**Re: Planning Application 19/0566**

**Address: 25 Greenacres, Read Burnley BB12 7PT**

**Description: Two story extension to side with excavated garden banking to increase parking.**

With respect to this application we would no longer wish to raise an objection. This is based on a drawing dated June 2019 No. JSA – 19 – 1220B.

June 2019
Scale 1:50th on A1
JSA - 19 - 12208

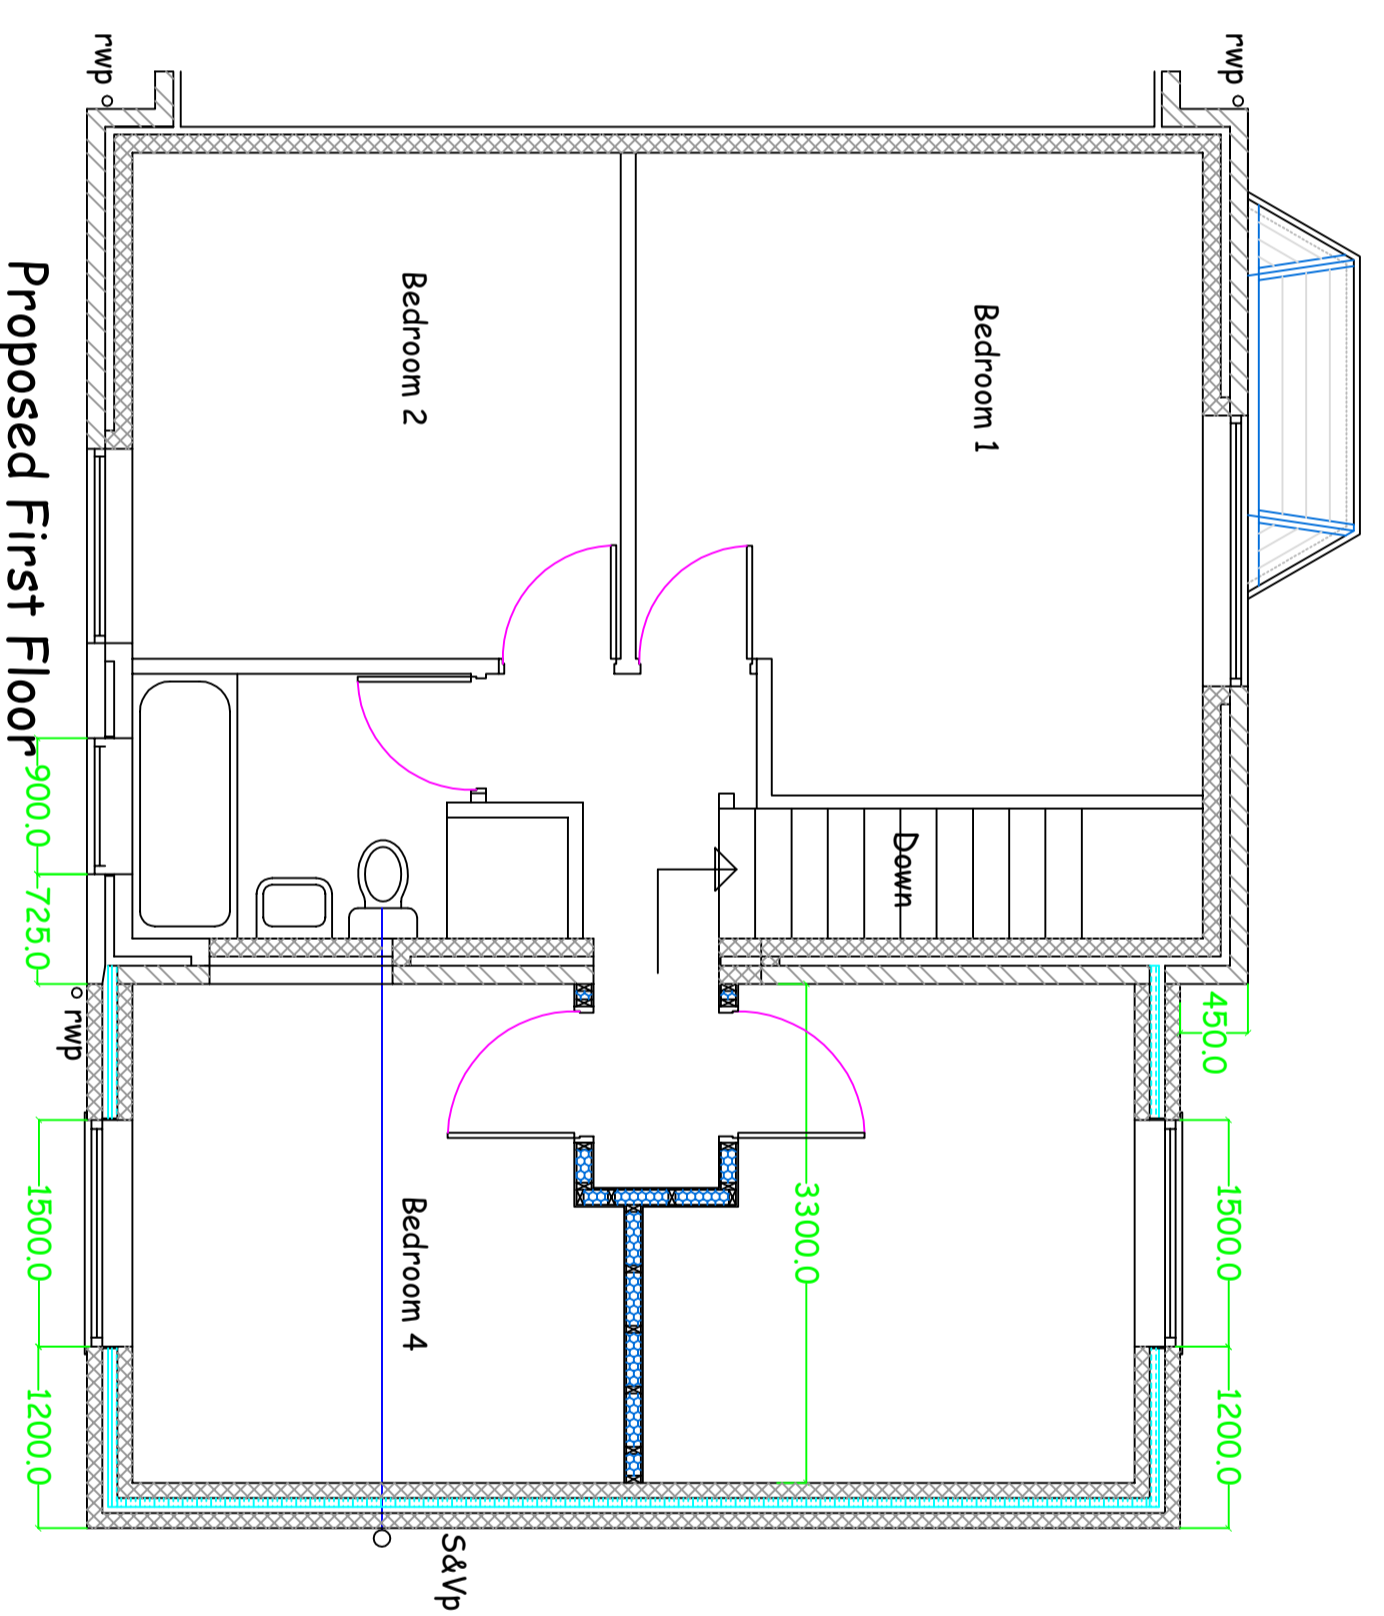
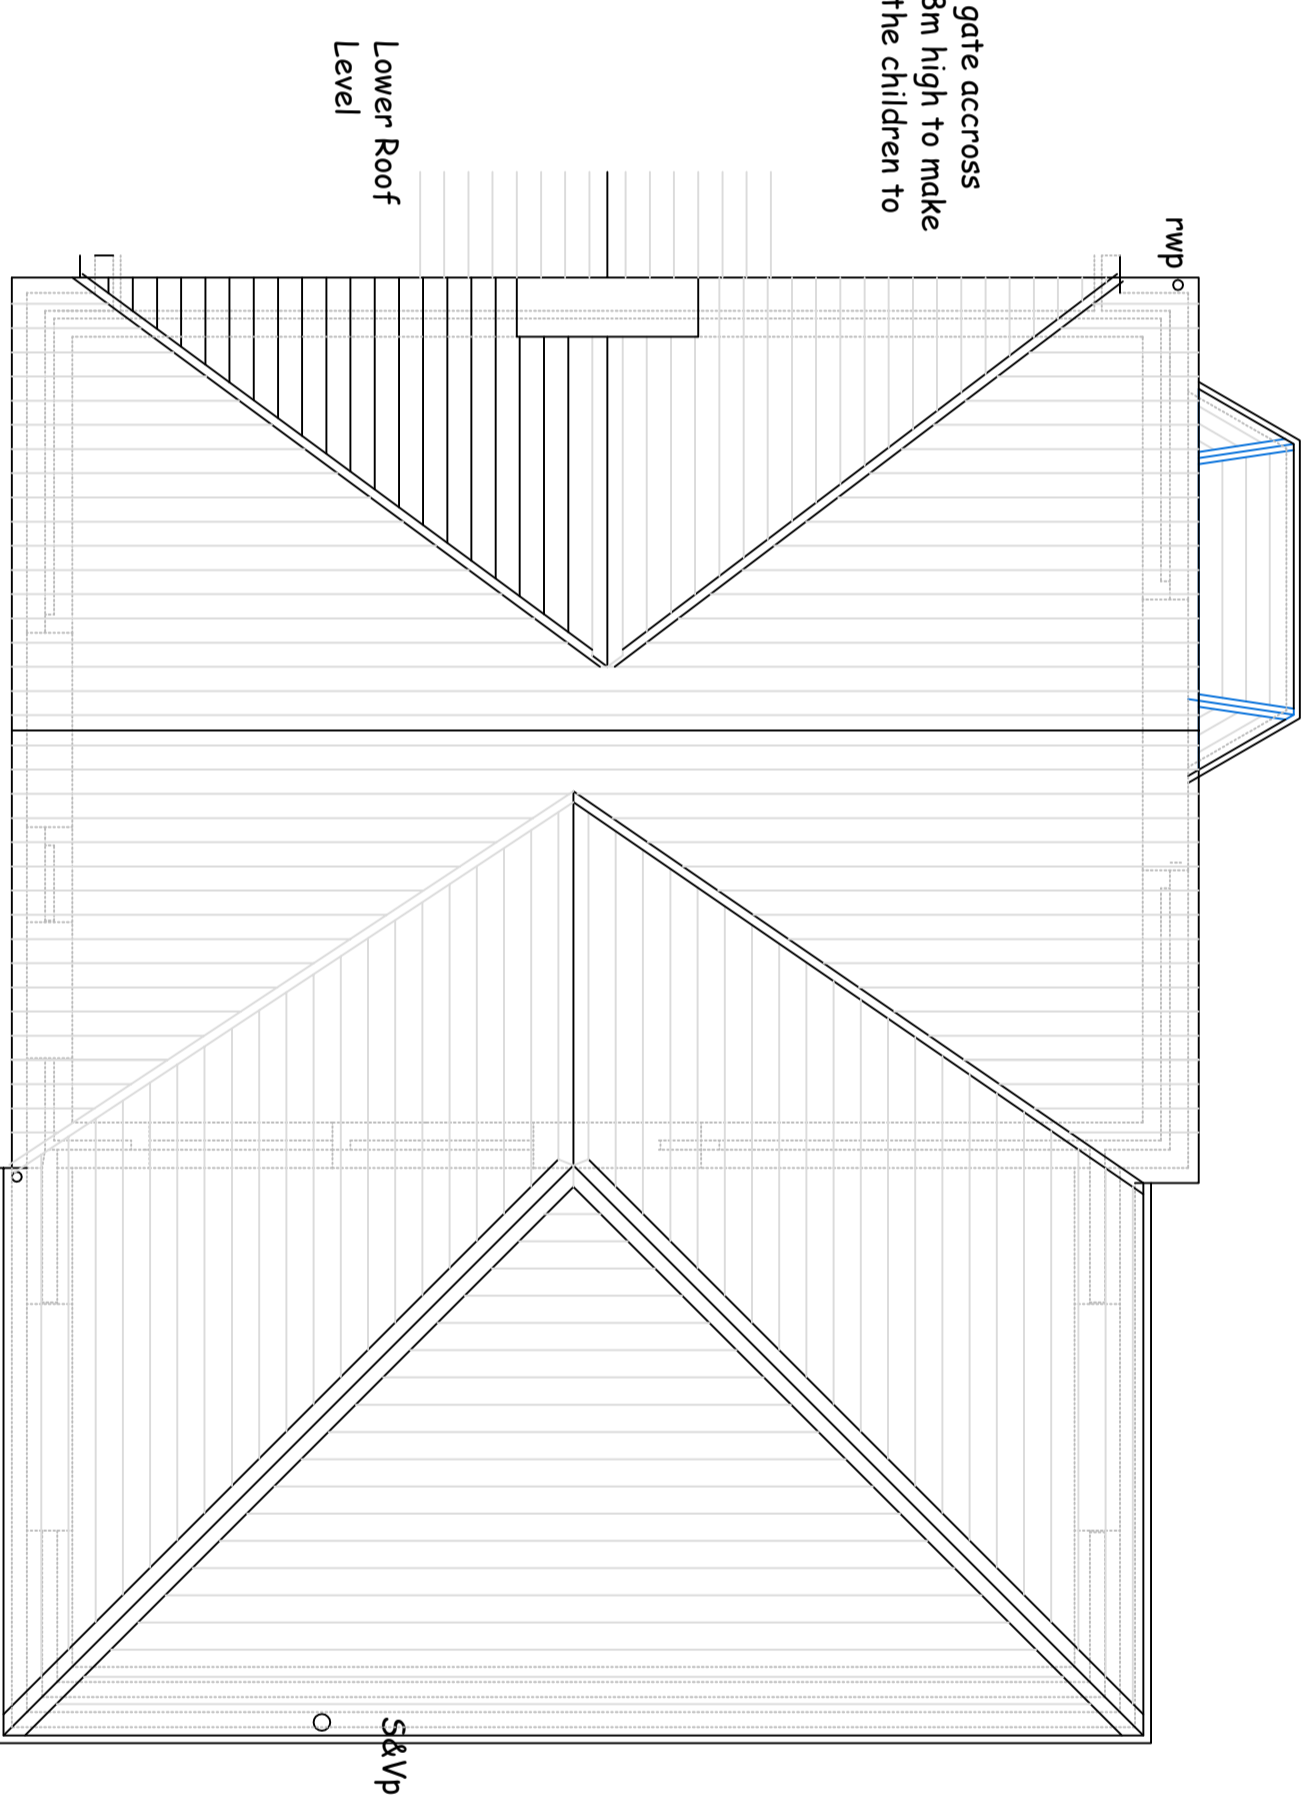
Concerns previously raised regarding the off street parking have been addressed.

The existing drive is to be widened towards the neighbouring property, the existing footway will need to be lowered so that there are raised kerbs between the two drives. It is noted that a fence is to be placed at the rear of the existing Street Light, it is expected that this will be of a solid construction and no more than 1m in height.
